Approval of details reserved by condition imposed under ref BN/23/15/PL relating to Condition No 5 - surface water drainage, 6 - discharge of any flows to watercourses and 7 - future access & Maintenance of any watercourse or culvert

Coniston Lake Lane Barnham PO22 0AD

Arun District Council have decided to **REFUSE details reserved by condition for the following reasons:**

Record of As Bolt Construction

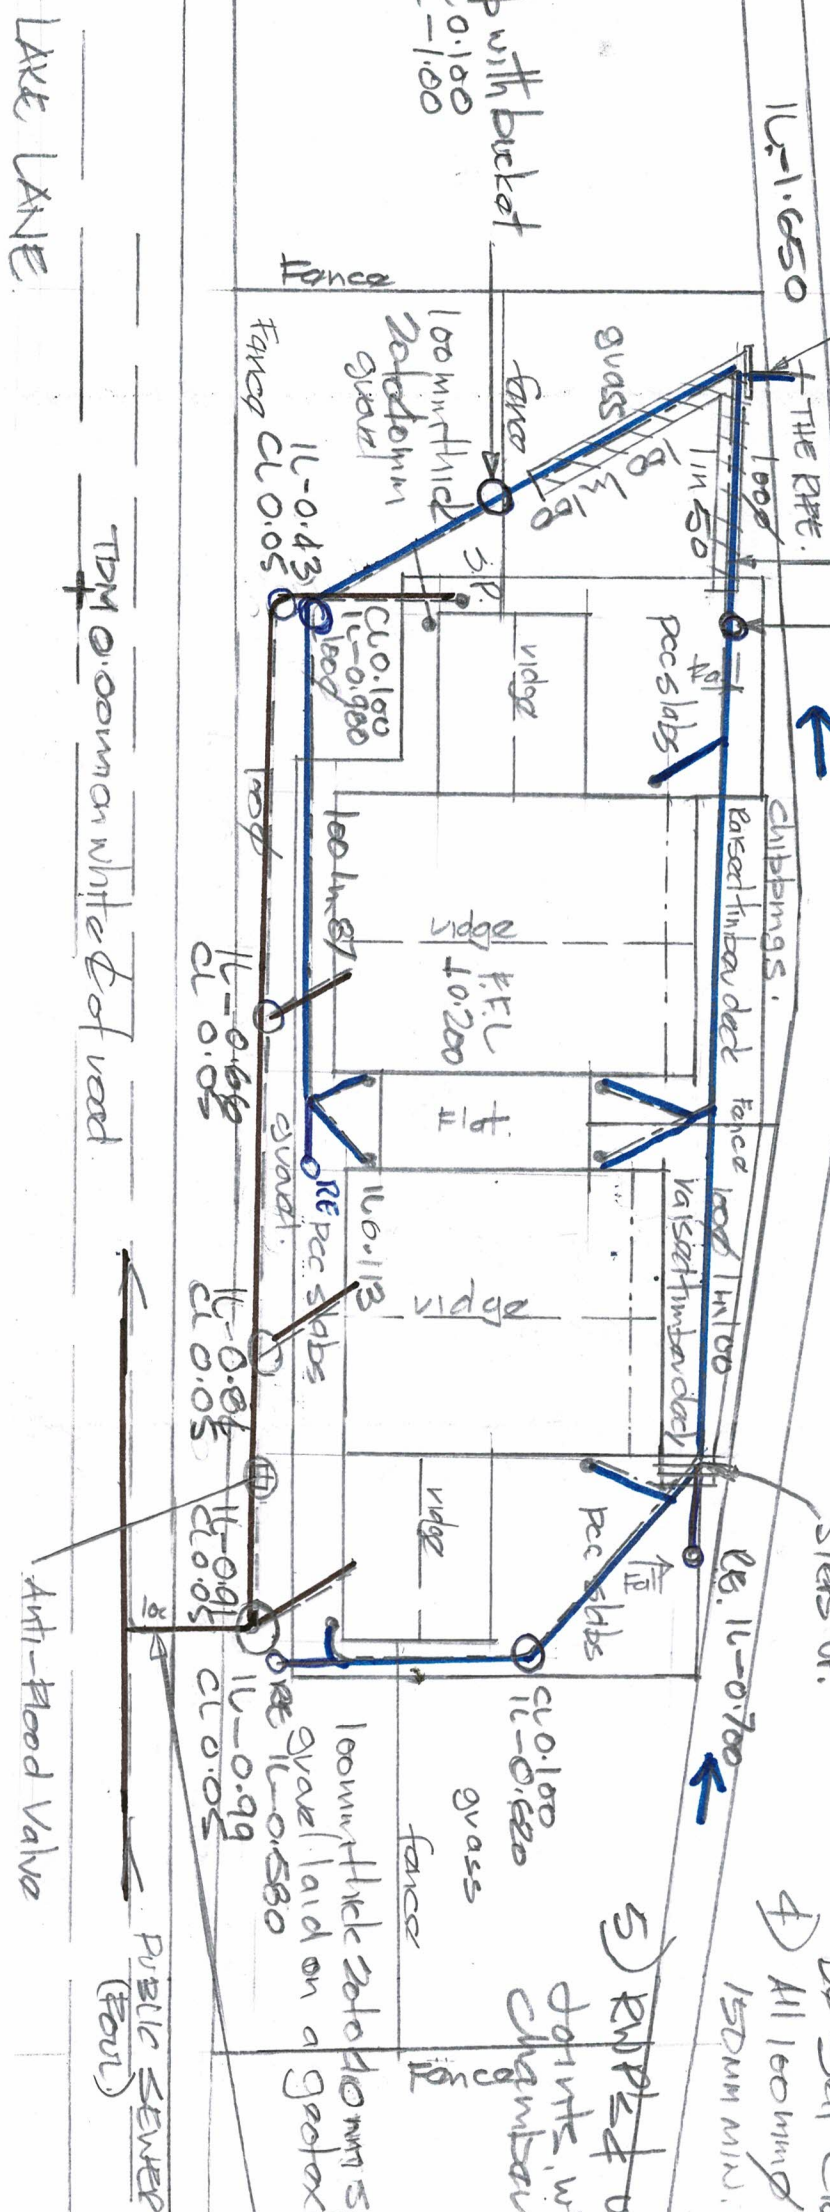
- Numerous invert levels have been changed. The invert level of the silt trap manhole is not clear (- 0.900?), neither is the rodding eye invert level. Please provide clarity on the drawing.
- Revised drawing 535/02 has not been received.
